### **Moorebank Intermodal Terminal**

Independent Traffic & Transport review of the MIC Staged SSD

**NSW Department of Planning & Environment**

8 October 2015 Revision: 2 Reference: 236935

Figure 4.1 Proposed Moorebank Avenue, Anzac Road and Moorebank IMT Access intersection

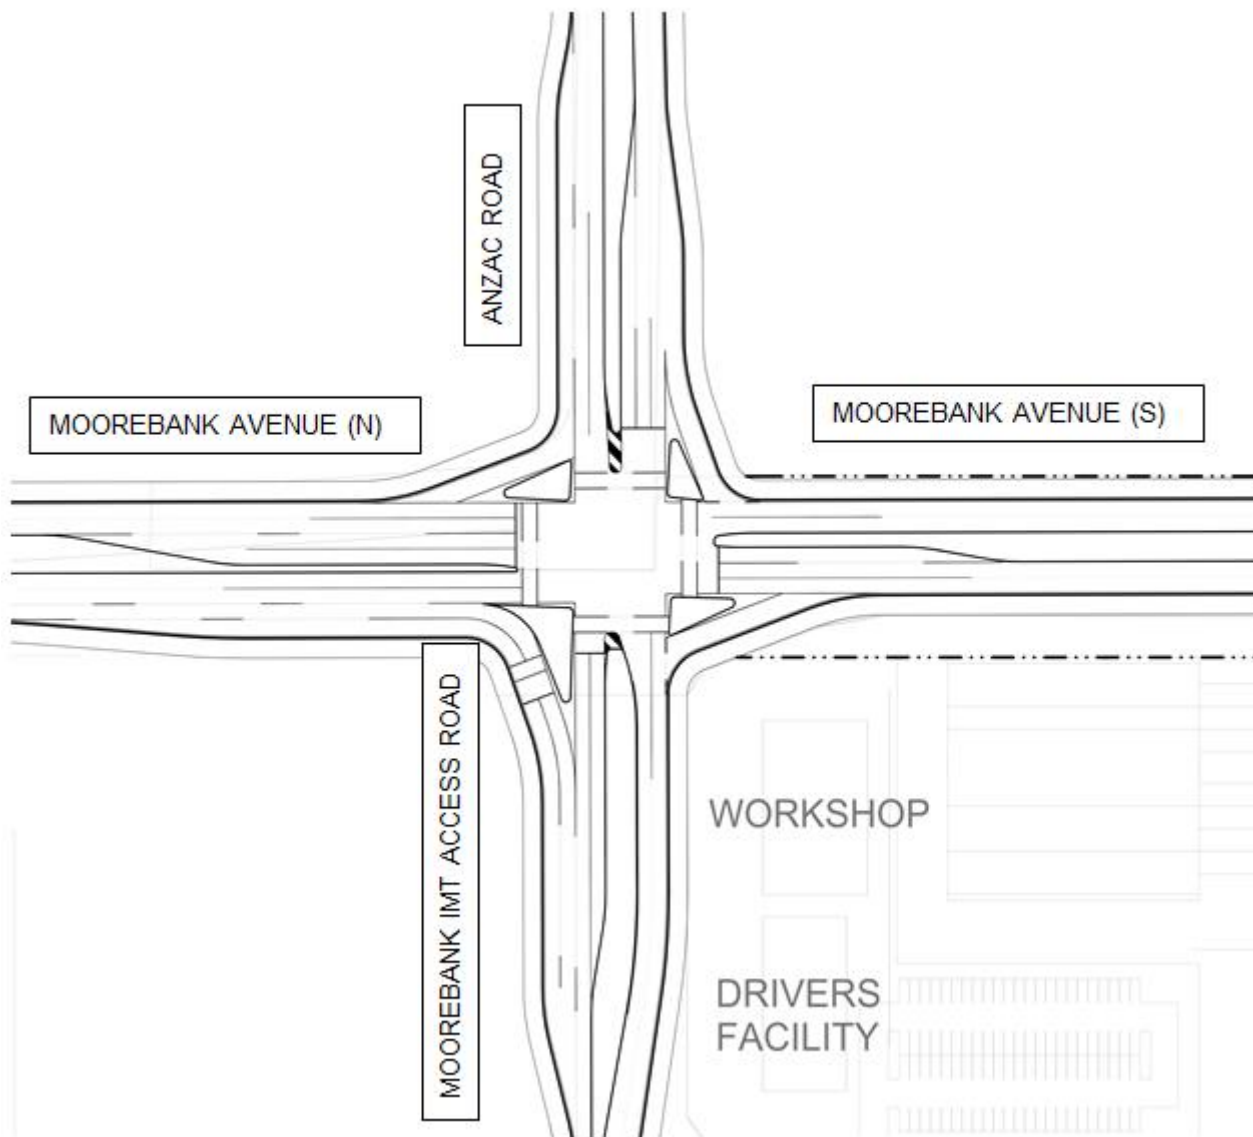
**Proposed mitigation measures should not remove any existing public transport or active transport provisions** without providing an alternative equivalent or improved provision. A concern about the proposed intersection adjustments (at Heathcote Road/ Moorebank Avenue) is that one includes the removal of a short bus lane. It is recommended that any existing bus lanes be retained or extended, rather than be removed.
